Subject: Public Comments on Fowler Guest Ranch, CU-23-00003

I am writing in regard to the proposed development for Fowler Creek Guest Ranch, CU-23-00003, and, explicitly, the Conditional Use Permit (CUP) application.

EXHIBIT 16 - SITE PLAN - FOWLER CREEK GUEST RANCH

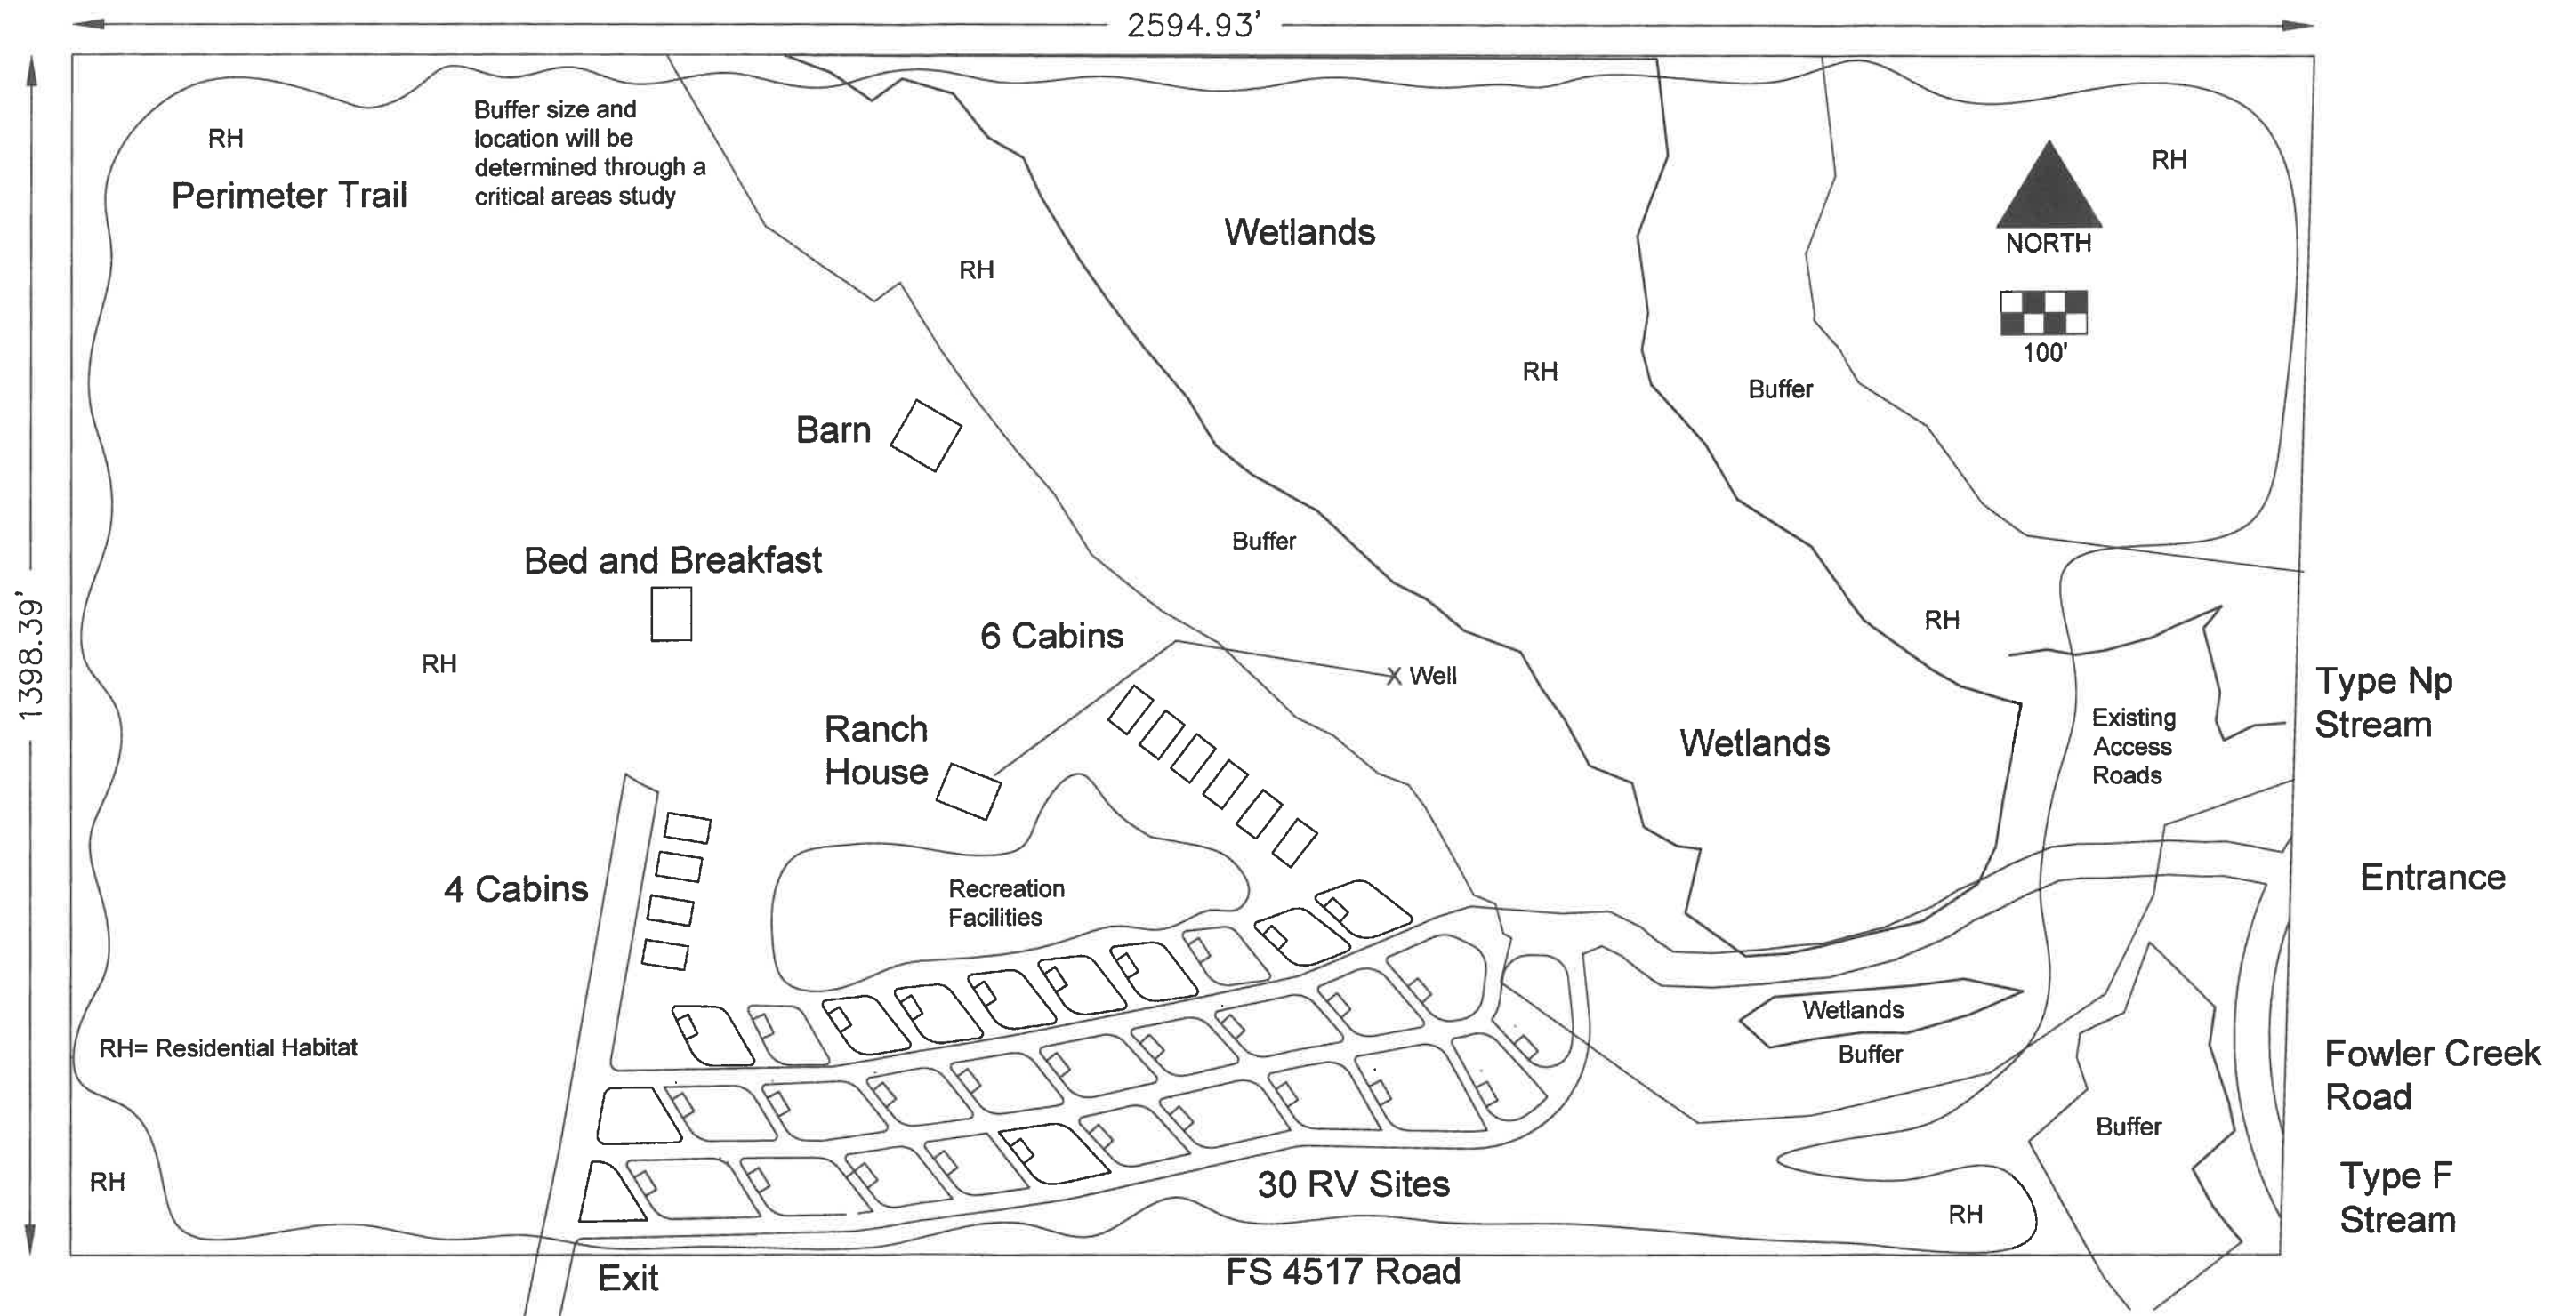
- Rural R-5 zoning, and Guest Ranch intended definitions;
- Site plan versus topographical outline and impact on earth, wetlands, and water;
- Traffic impact versus road capacity and character, emergency egress, and fire safety.
